**Subject:** RE: Planning Consultation on: M/39/22/DOC

**Application No:** M/39/22/DOC  
**Registered:** 11th April 2022  
**Site Address:** Briarfield Ancton Lane Middleton-on-sea PO22 6NL  
**Description of Works:** Approval of details reserved by condition imposed under M/141/21/HH relating to condition 5-surface water drainage.

At this stage we **would not recommend discharge of conditions** until the following comments are addressed.

Surface Water Chamber & Soakaway Constructional Details scale 1:25

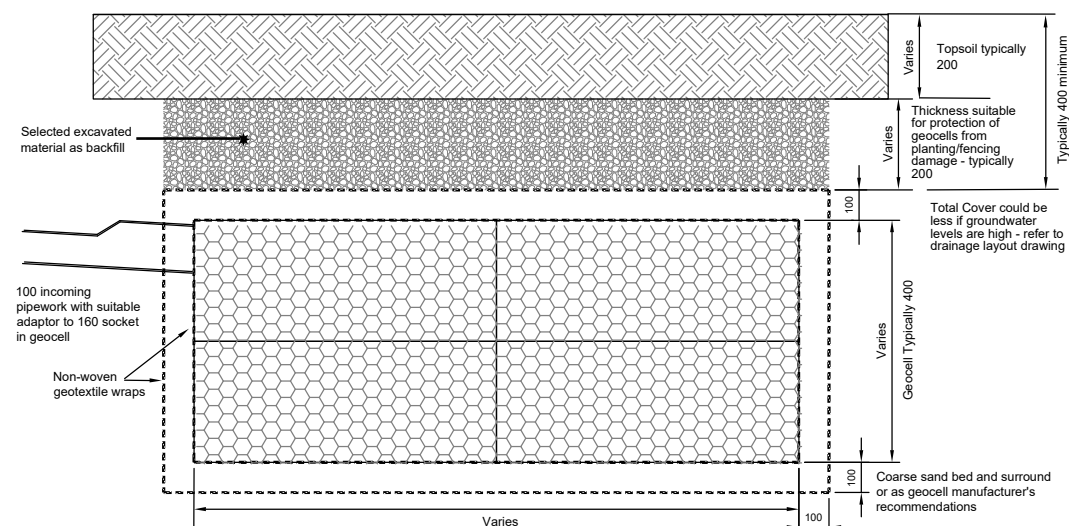
5. The angle between the pipe entering the soakaway and edge of the soakaway crates is approximately 32°. The cross section drawing of the geocellular storage tank states a suitable adaptor will be used to make this connection. Please provide a detail of exactly how this will be achieved (e.g. a detail of the adaptor).

Detailed
Drainage
Layout
Scale 1:200

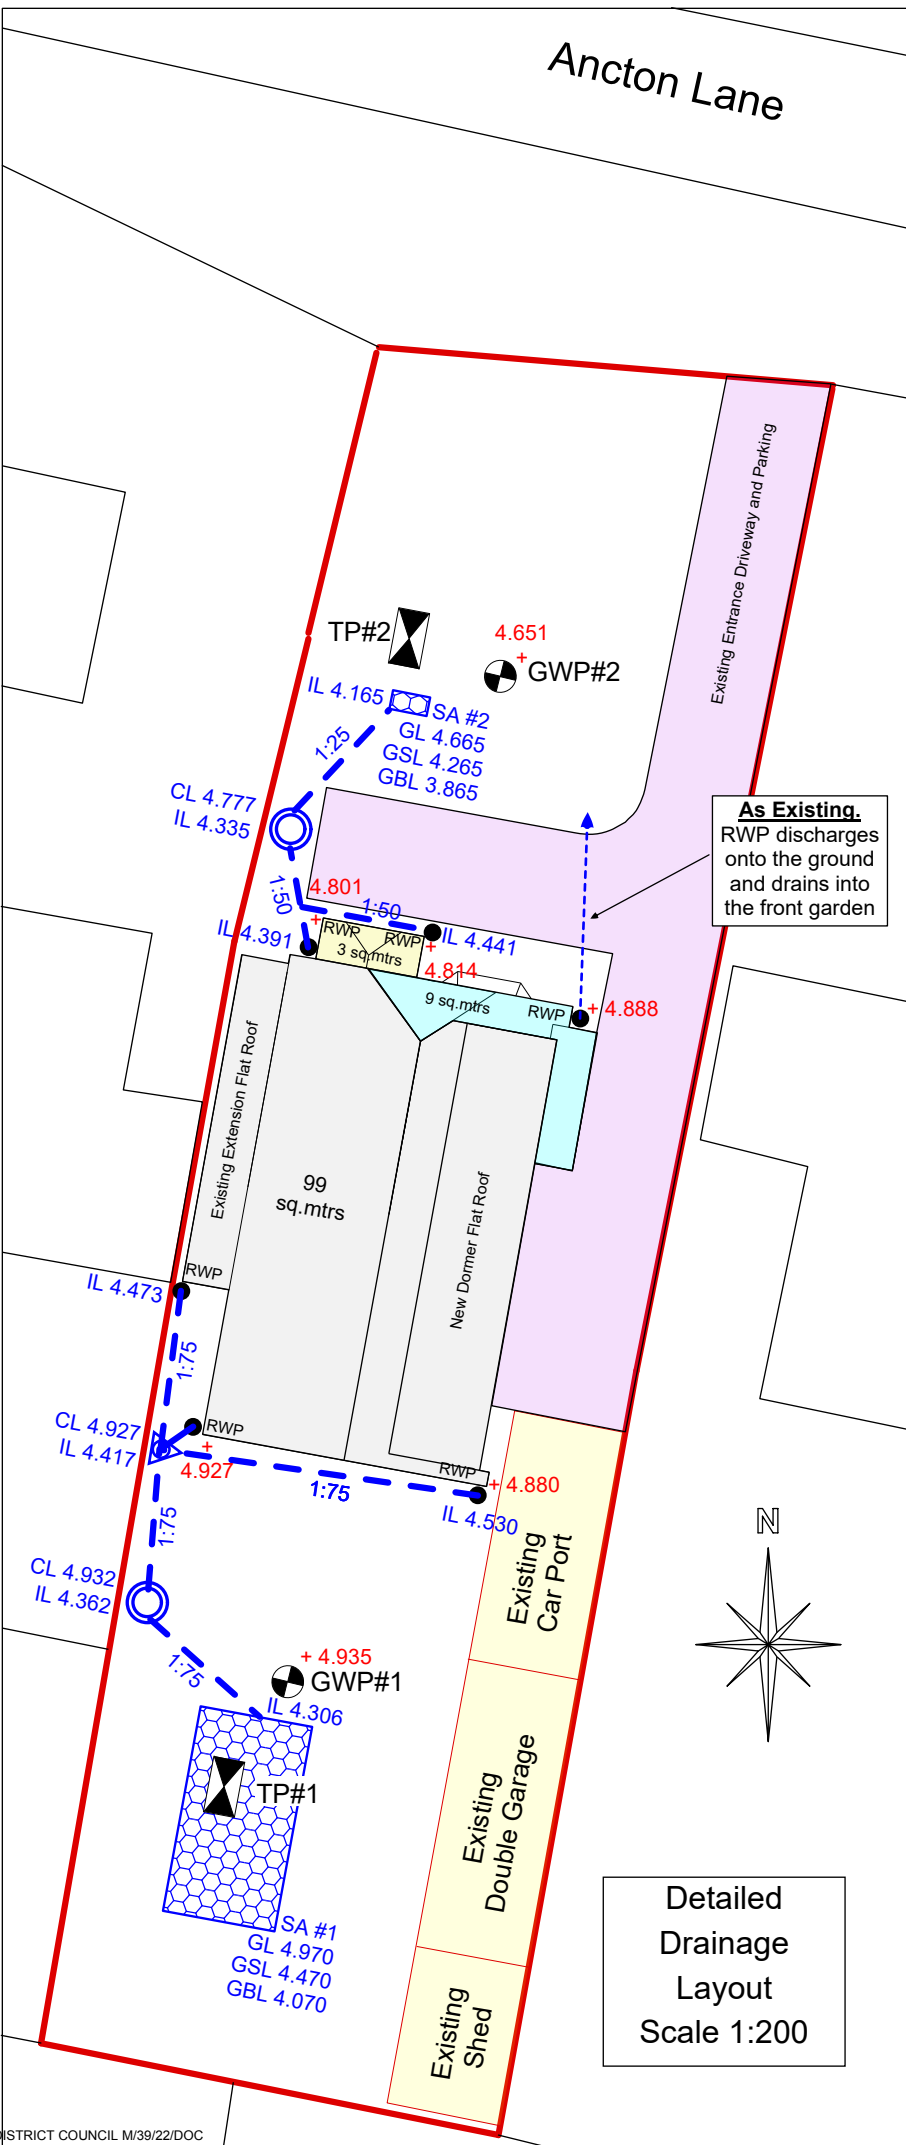
1. Additional information is required on the design drawings.
  - A manufacturer specification for the crates is required.
  - The drainage layout plan should include a scale bar.

- Location of the access point for maintenance and inspection of the soakaway should be stated on the drawings.
2. The calculations assume base infiltration will be available. This does not account for siltation within the soakaway base over the lifetime of the soakaway, which typically is not acceptable to building control. The design calculation(s) should be rerun excluding base infiltration.

3. The existing garage (and shed) appear to be located ~3.6m from the proposed soakaway, if this is not a temporary building, the impacts of the soakaway being located within 5m of this structure should be considered.

- It is also acknowledged that a 10m easement is sometimes recommended where soakaways are used in, or above, deposits of chalk (typically low density), where paleo-karstic surfaces are present, or where ground instability may occur. It should be confirmed that this additional easement is not required for the garage, other outbuildings, or house, in this instance.

4. The applicant should confirm the existing drainage for the; shed, garage, and carport to ensure this does not drain to an existing soakaway under the garden. If these areas do drain to an existing soakaway in the garden the following applies;

6. The applicant should confirm that the soakaway is located outside of the root protection zone (RPZ) for the trees located within adjacent properties gardens. *It is noted that the boundary of the site is adjacent to a TPO boundary, although it is unclear from the drawings if any trees will be affected by the position of the proposed soakaways.*

7. The applicant should provide a statement or sketch plan to confirm that surface water flows will not be directed into the property in the event that the soakaway was to fail, or its capacity become exceeded. This is particularly important if the rear door of the property provides flush access with no threshold.
